Our Ref: P/56/22/DOC

Approval of details reserved by condition imposed under P/134/16/OUT relating to conditions 30-programme of archaeological works and 32-protection of proposed dwelling from noise generated by Osbourne Refrigeration site.

Land North of Sefter Road & 80 Rose Green Road Pagham

Arun District Council have decided to **REFUSE details reserved by condition for the following reasons:**
Arun District Council officers are unsatisfied that the mitigation measures provided would satisfactorily address noise levels within private dwelling spaces, both internally and externally.

Figure 16/0383/TH01

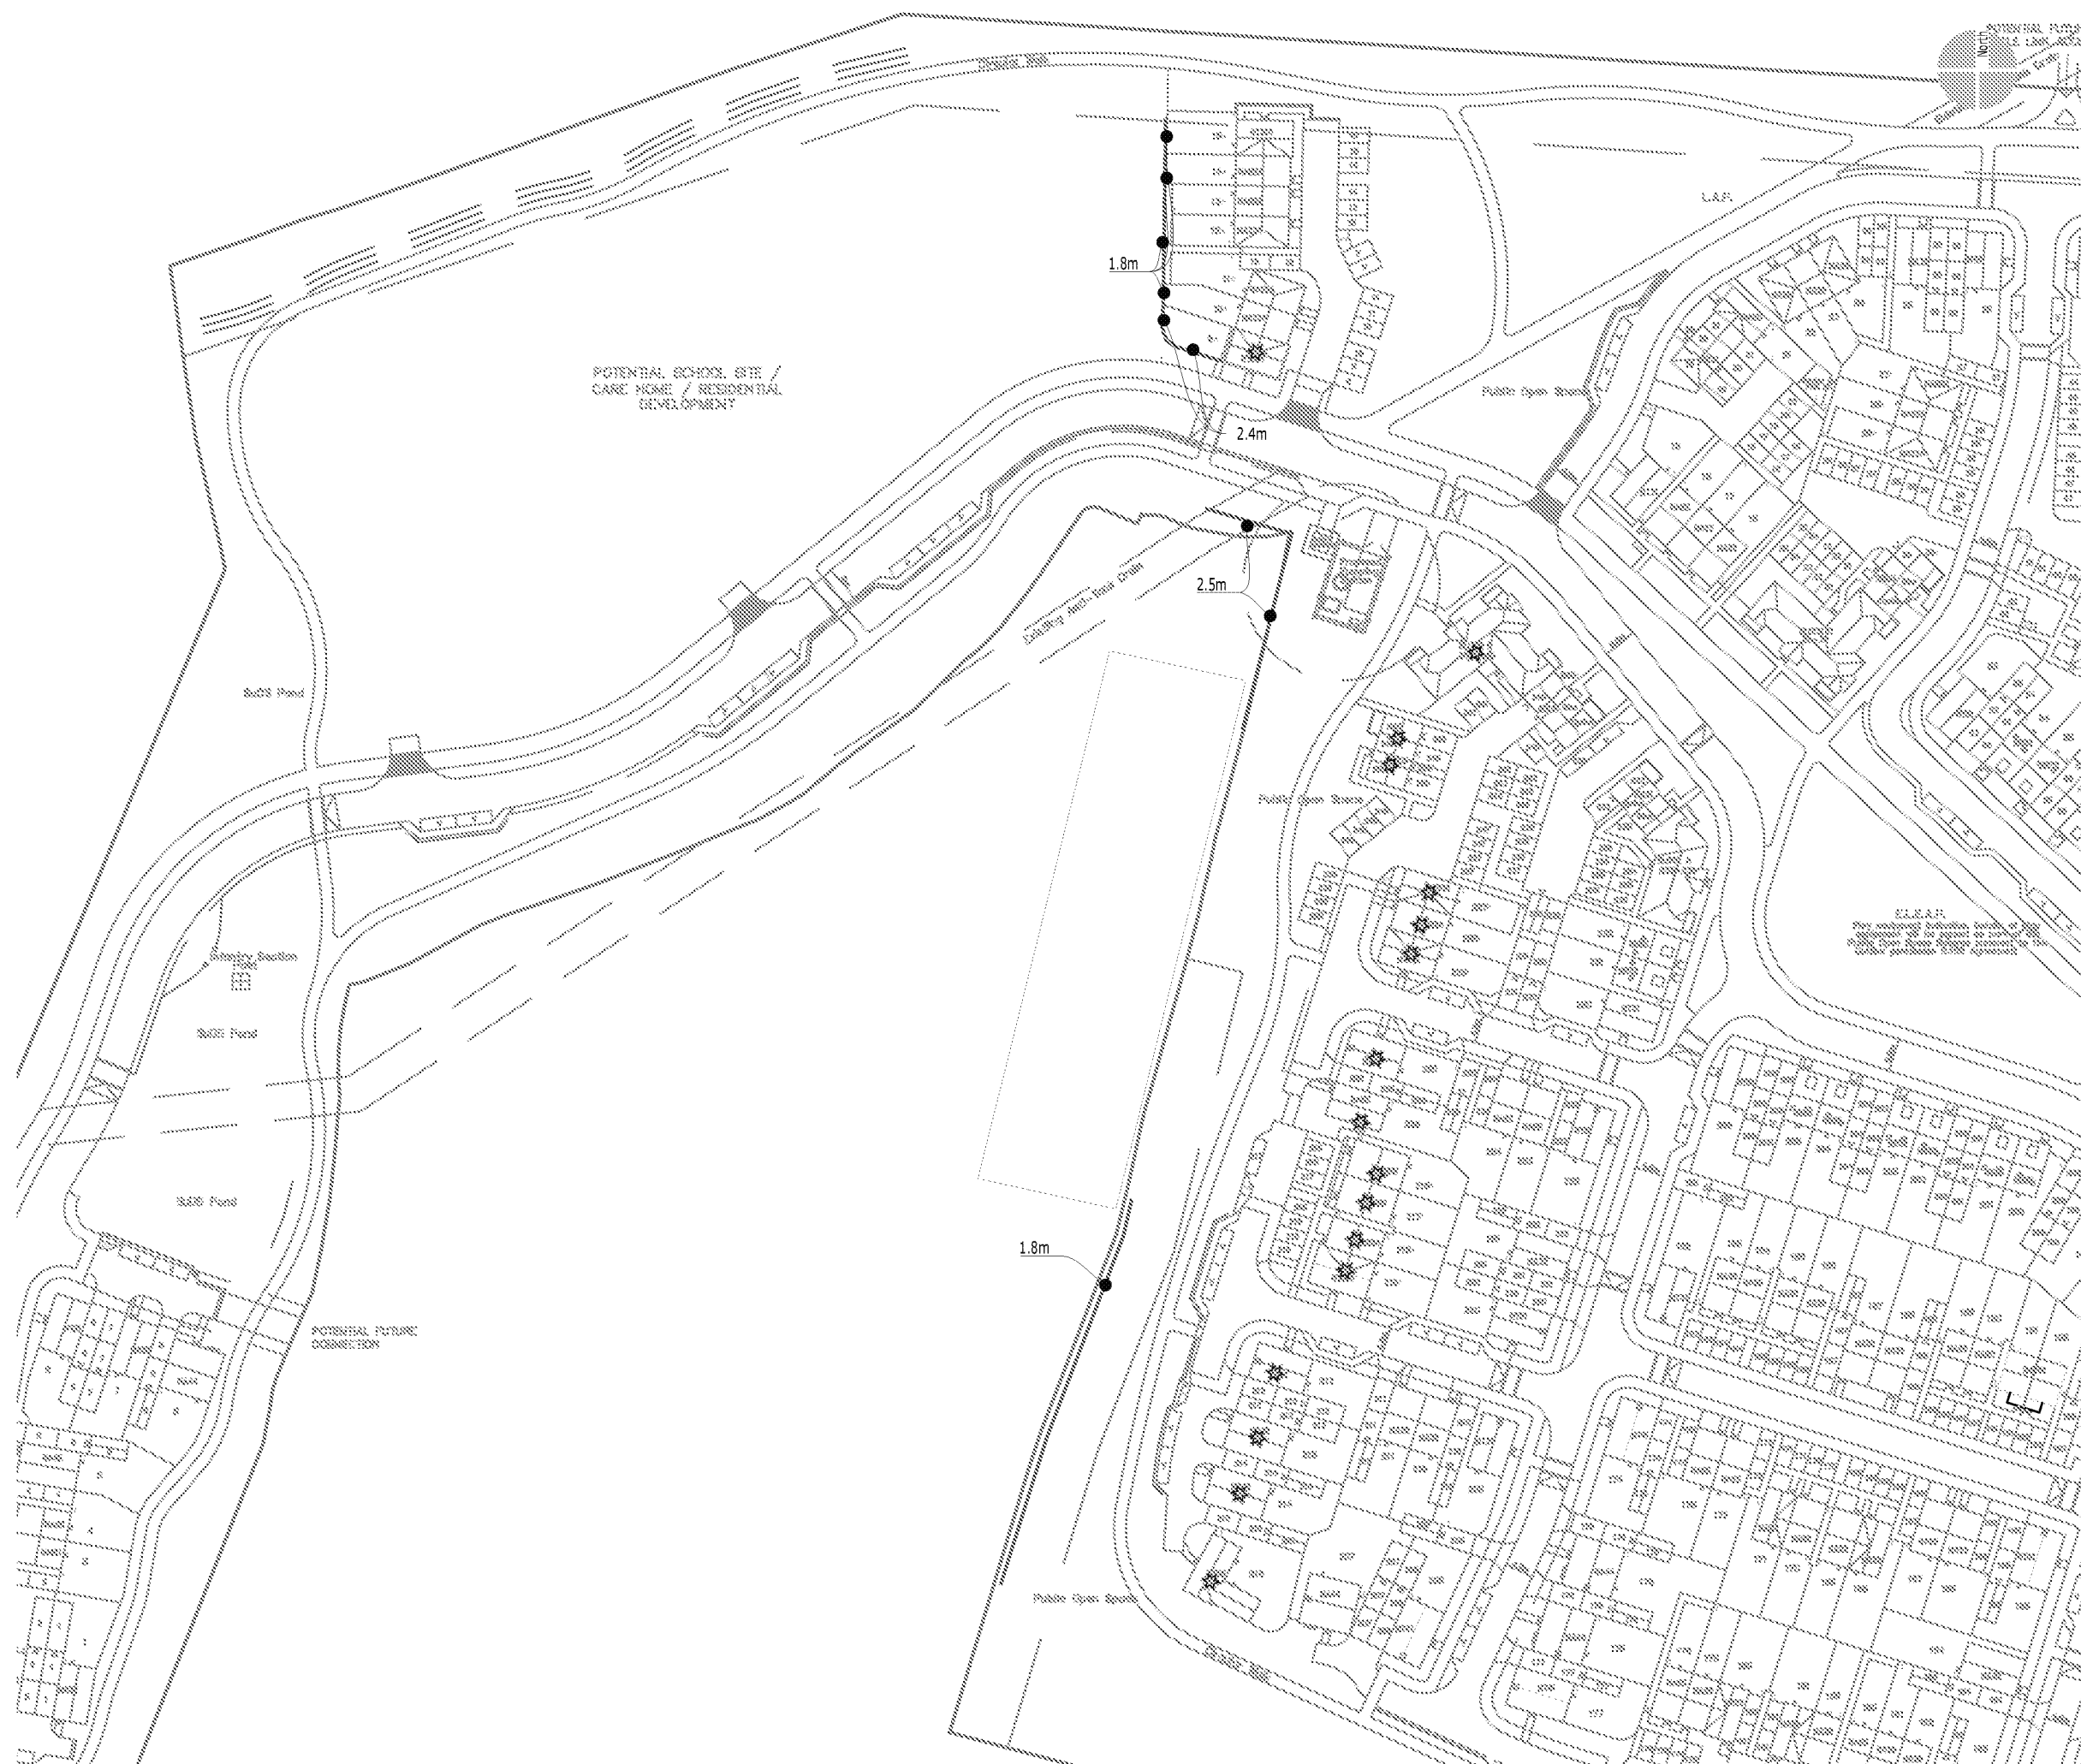
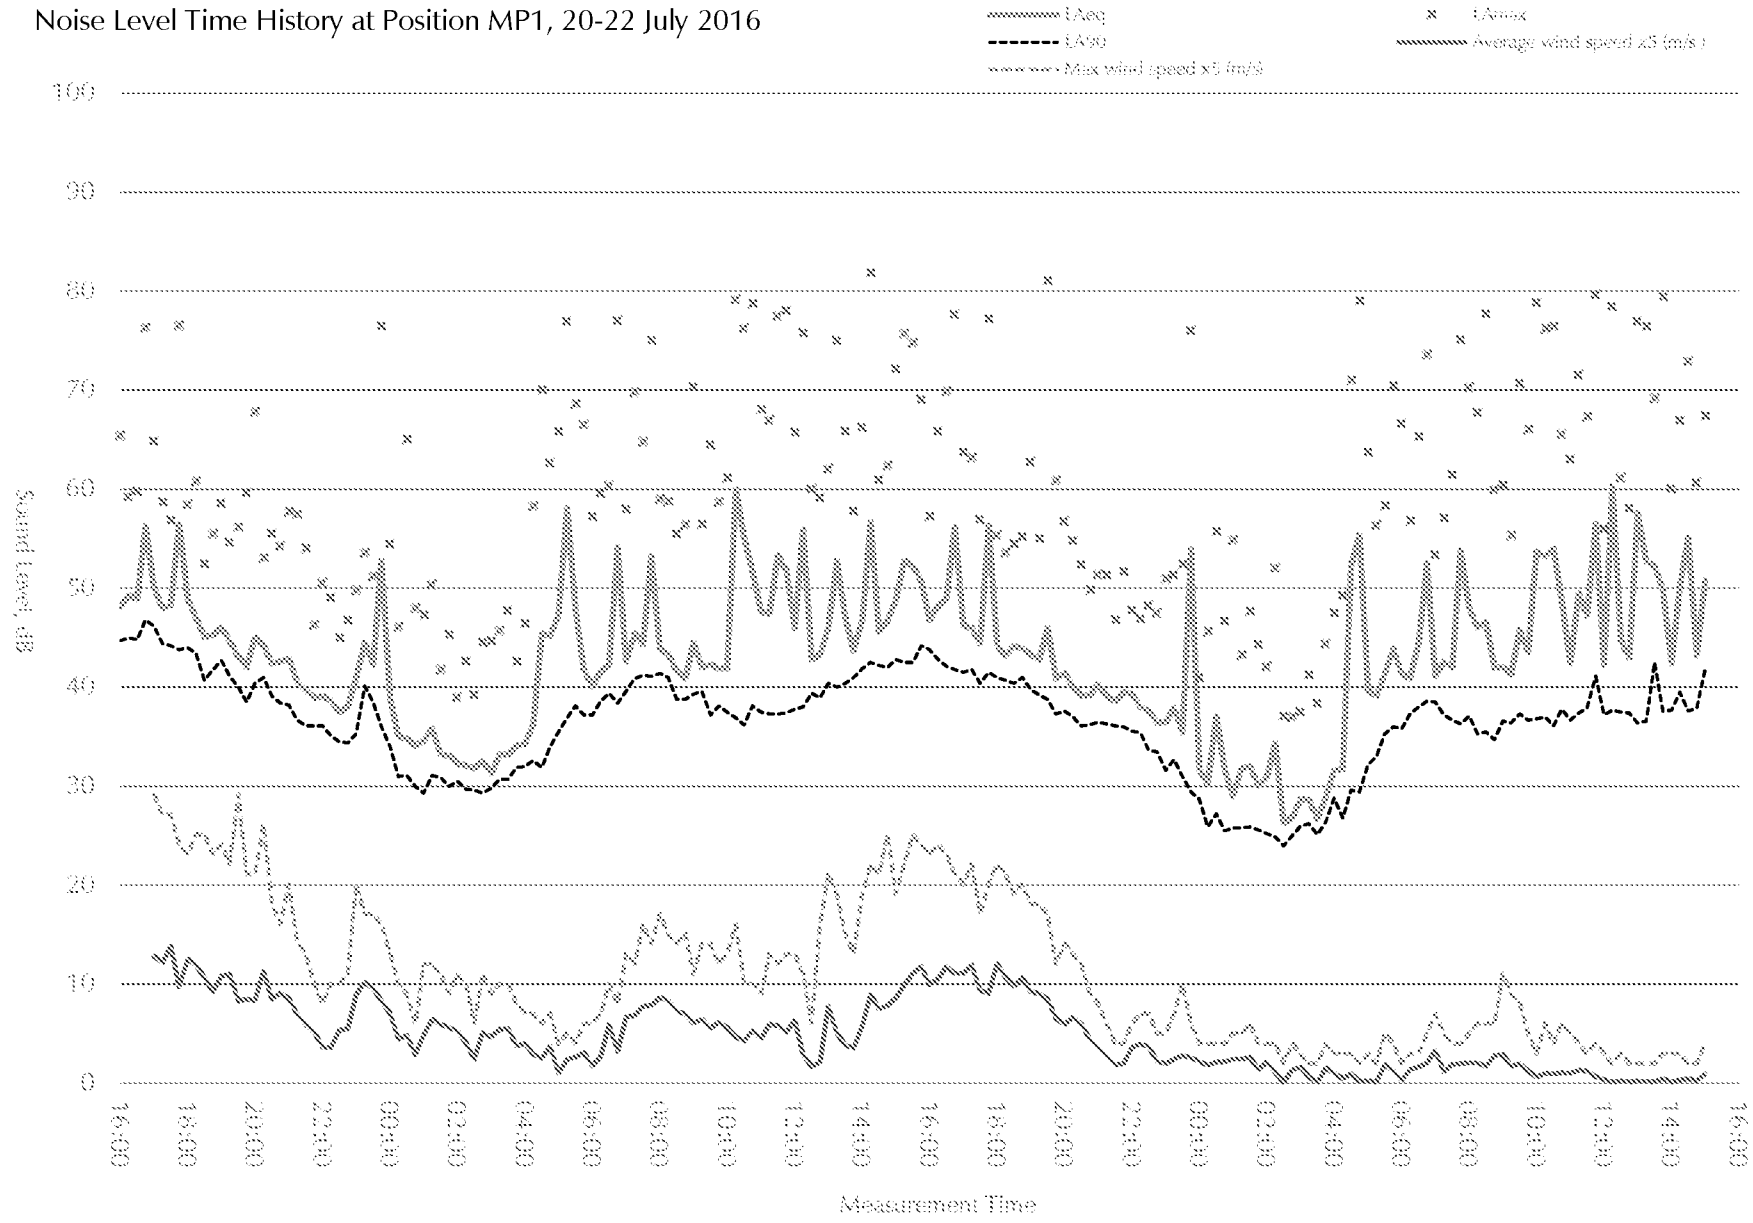
Environmental Health Officers have objected to the information submitted. The noise assessment (ref. 16/0383/R2) relies on the noise calculations within report reference 16/0383/M1 Rev 1 (submitted as part of application P/134/16/OUT) which was undertaken with a 3m high acoustic fence. The submitted

proposals suggest mitigation of a 2.5metre acoustic fence, and therefore it has not been sufficiently demonstrated that noise levels would not result in unacceptably adverse harm to the amenity of future occupiers. Additionally, the areas to the north which were originally intended to be developed as a scout hut have not been acoustically assessed and therefore Arun District council cannot be satisfied that appropriate mitigation is proposed.
